North Littlehampton, Phase 5 Spine Road CH 0-180m & 700-1020m

Stage 1 RSA – Road Safety Audit Response Report

Stage 1 RSA - Road Safety Audit Response Report [Rev. P1]

13. Identified Road Safety Audit Matters location plans

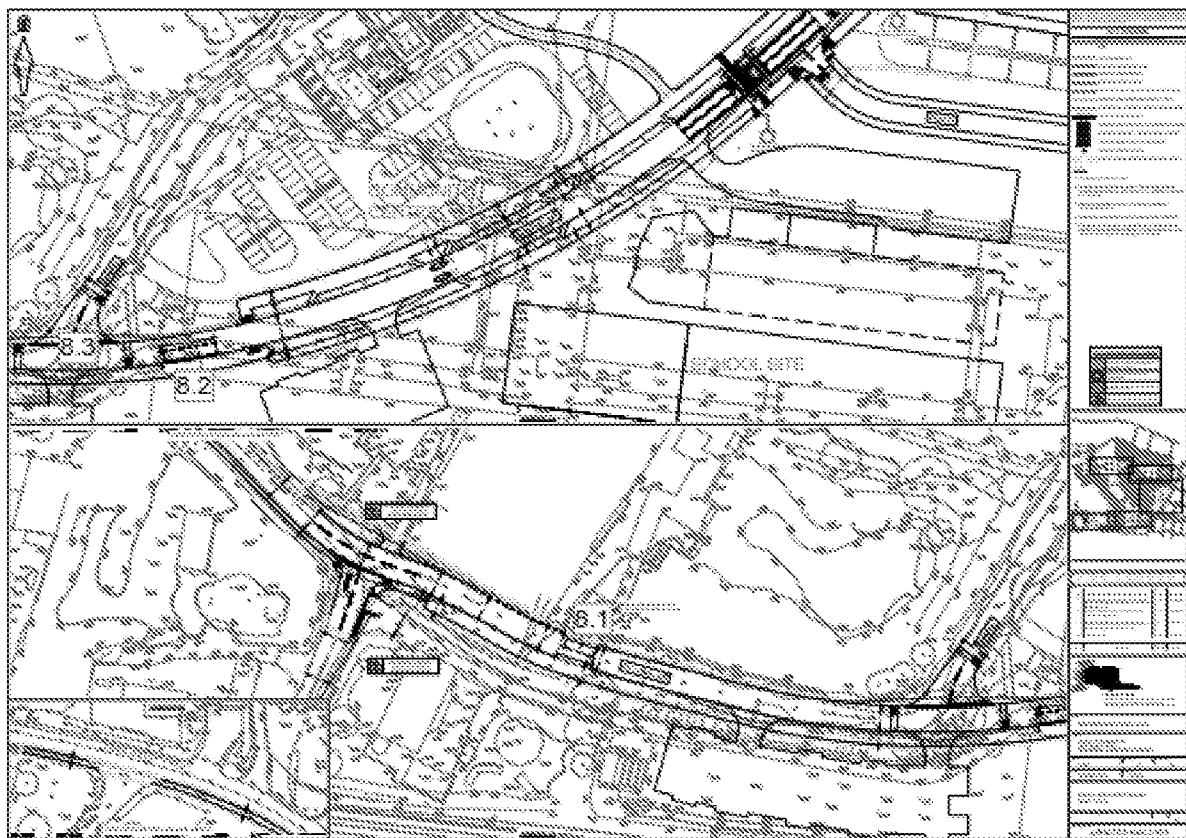
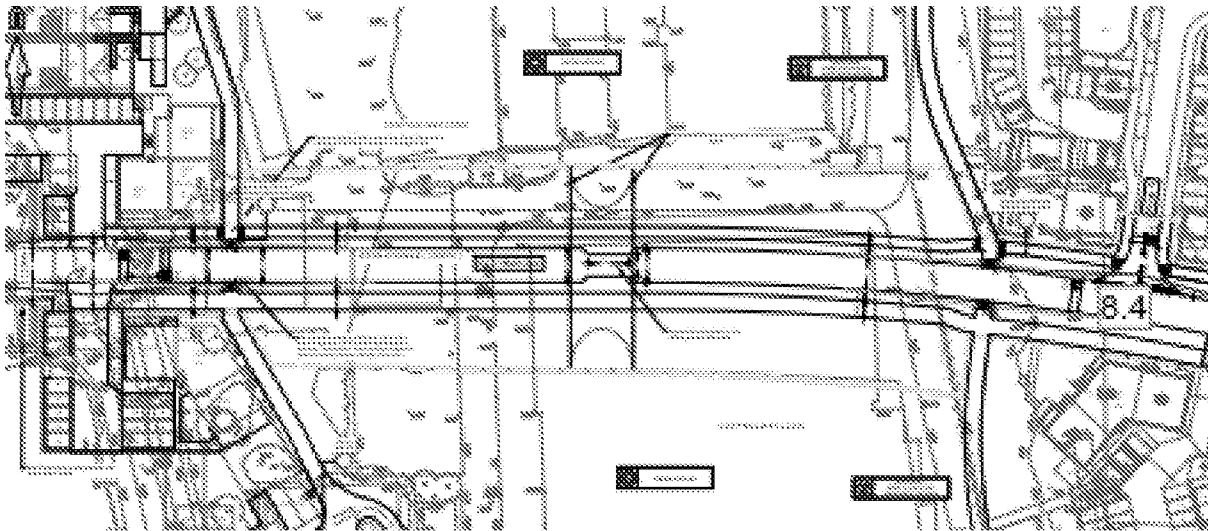
Item	Problem	Recommendation	Designer's Response	Overseeing Organisation Response	Agreed RSA Action
8.1	Location: Private access chainage 970 Summary: A carriageway narrowing is detailed adjacent to a private vehicles access. Check access is maintained. There is a carriageway narrowing feature detailed adjacent to a private driveway access. Check vehicle tracking to ensure vehicles can use the access safely. Type of Conflict/Collision: Vehicles unable to use vehicles access safely.	Carry out vehicle swept path analysis to ensure access can be used safely.	Accepted. A vehicles swept path analysis has been carried out for the nearest access to the road narrowing (worst case scenario). The tracking shows cars can still use the access safely with the narrowing. The narrowing restricts the road width locally to 4.1m, which allows two cars to pass each other. Giveway marking has also been added to give priority to buses and cars travelling westbound.

Item	Problem	Recommendation	Designer's Response	Overseeing Organisation Response	Agreed RSA Action
8.2	Location: Spine Road, Junction Road 11 Chainage 860.00 Summary: Bus stop located on approach to side road junction. There is a bus stop located on the approach to the side road junction with Road 11 at Chainage 860.00. This will result on any vehicles overtaking a stationary bus approaching the junction on the wrong side of the road risking a head on collision with a left turning vehicle out of the side road. Relocate bus stop. Type of Conflict/Collision: Head on collisions at junction.	Relocate bus stop away from junction.	Accepted. The bus stop has been relocated further north, approximately in the middle of the proposed school access and parking area to the south of the community centre.

8.3	Location: Spine Road junction with Road 11 Summary: No pedestrian footway facilities at junction. A side road junction is detailed without any pedestrian footway facilities. Check to ensure if any pedestrian facilities are required at junction and provide if required. Type of Conflict/Collision: Pedestrians having to walk over verges at junction.	Check if pedestrian facilities are required and provide if necessary.	Not accepted. No pedestrian facilities are required along Road 11, and therefore no footways have been added.

Item	Problem	Recommendation	Designer's Response	Overseeing Organisation Response	Agreed RSA Action
8.4	Location: Spine Road junction with Road 4 Summary: No facility to enable cyclists to access exit from Road 4 and join shared use path on opposite side of road. There is a side road junction detailed without any facility to enable cyclists to join/exit from the shared use path to Road 4. Provide facility to enable cyclists to access exit from shared use path to join side Road 4. Type of Conflict/Collision: Cyclists unable to access / exit path at junction.	Provide facility to enable cyclists to access / exit path at junction.	Accepted. A 3m wide cycle facility has been added opposite the junction to aid cyclists movements between Road 4 and the shared-use footpath on the other side.
